Re: SSD 6801 Mod 3 QuarryWEST Project, DEXUS Estate, Warehouse and Distribution Centre, Reconciliation Road, Pemulwuy, section 96 modification application

I refer to the above section 96 modification application received on 28 February 2017 which seeks to make amendments to the layout of warehouses B2 and B3 in Precinct B.

C NORTH ELEVATION - WAREHOUSE B2
Scale 1:300

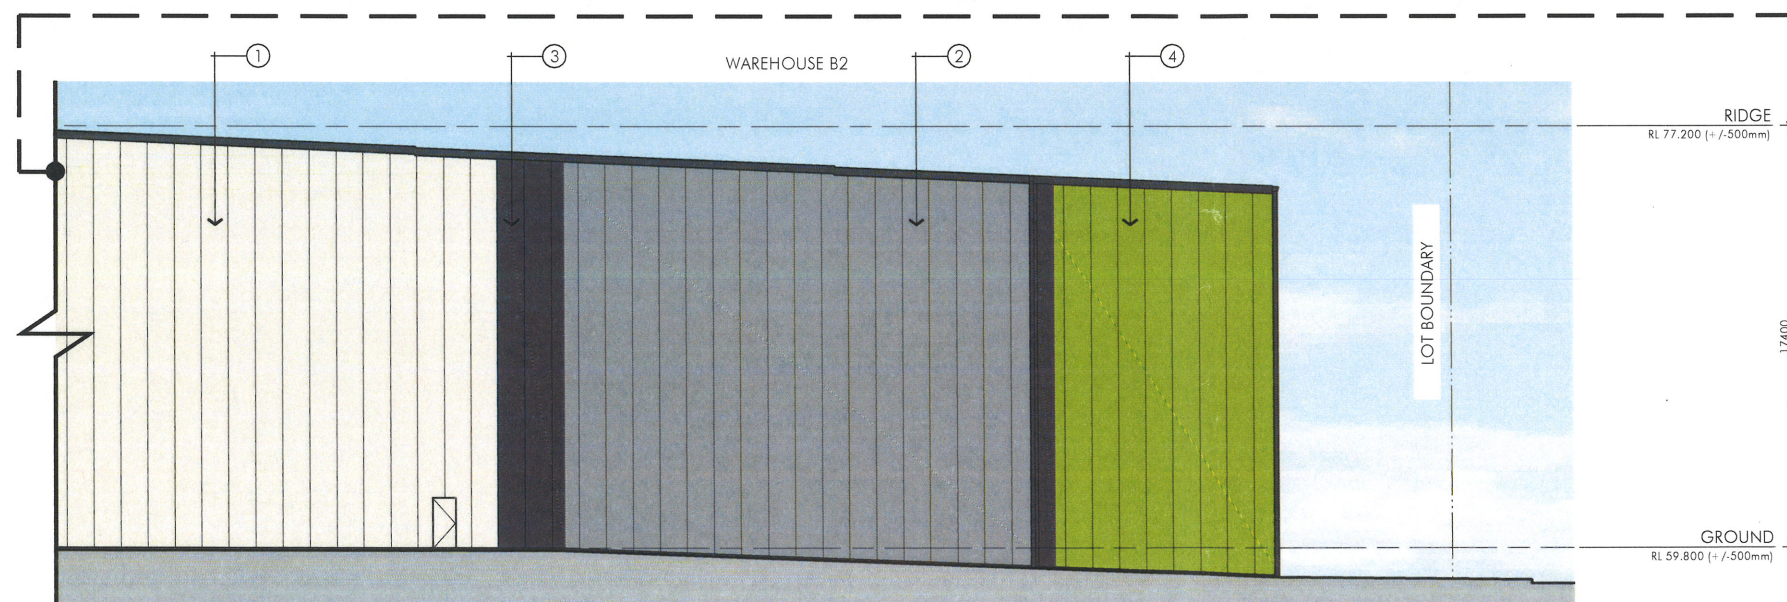
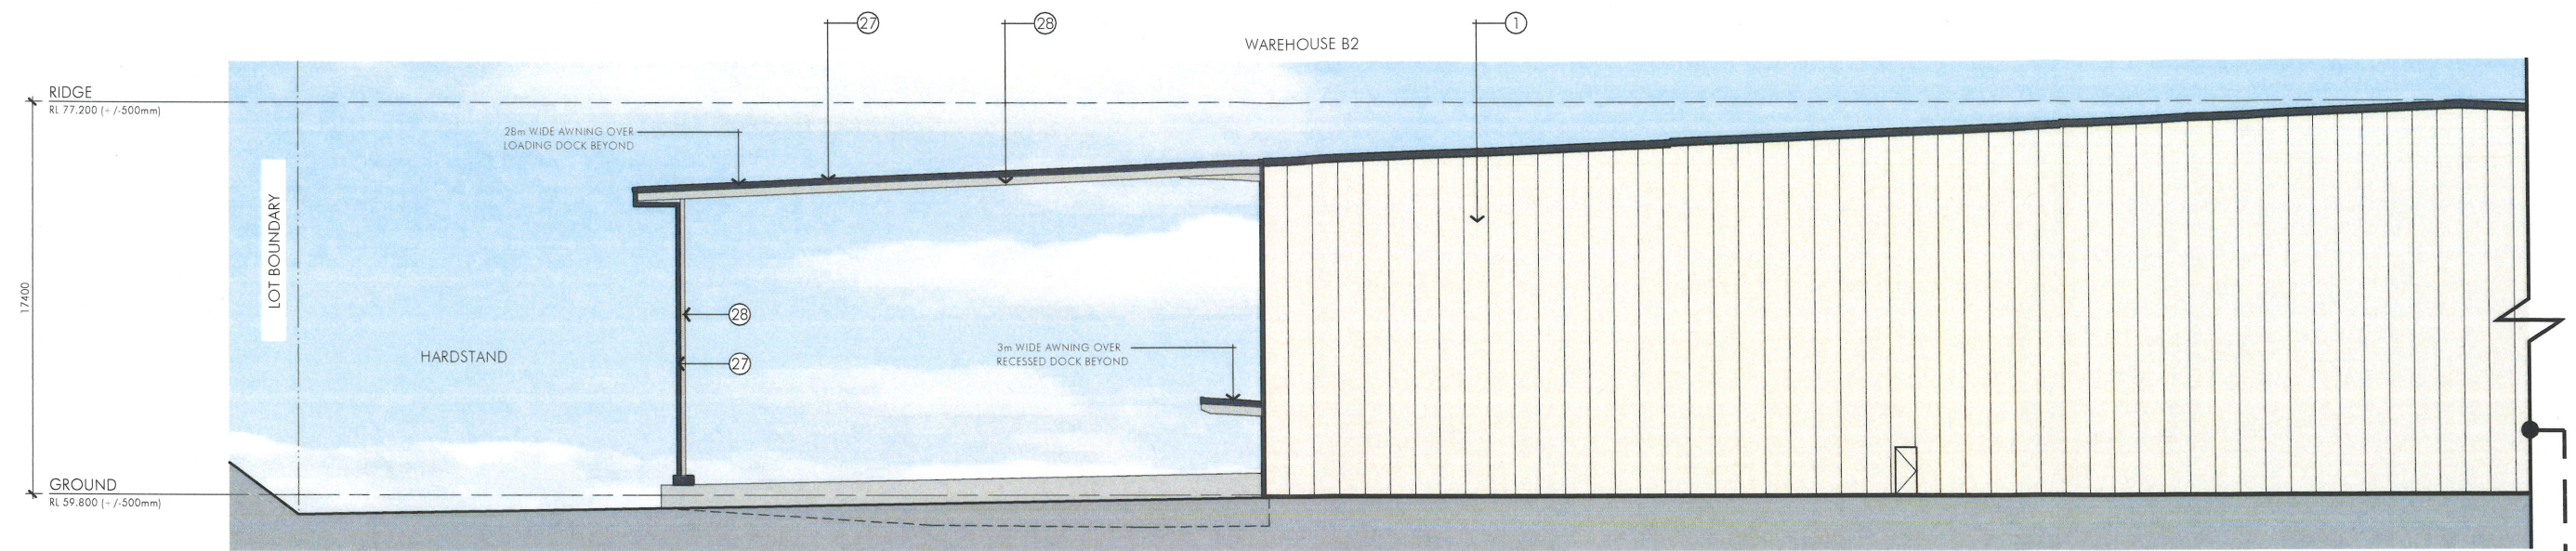
With regard to the proposed building height variation for Warehouse B2, would you please request the Proponent provide details of the necessity for the increased height, for example is this essential to accommodate a racking system. The Applicant is to demonstrate that they are unable to adhere to the maximum permitted building height of 15 m.
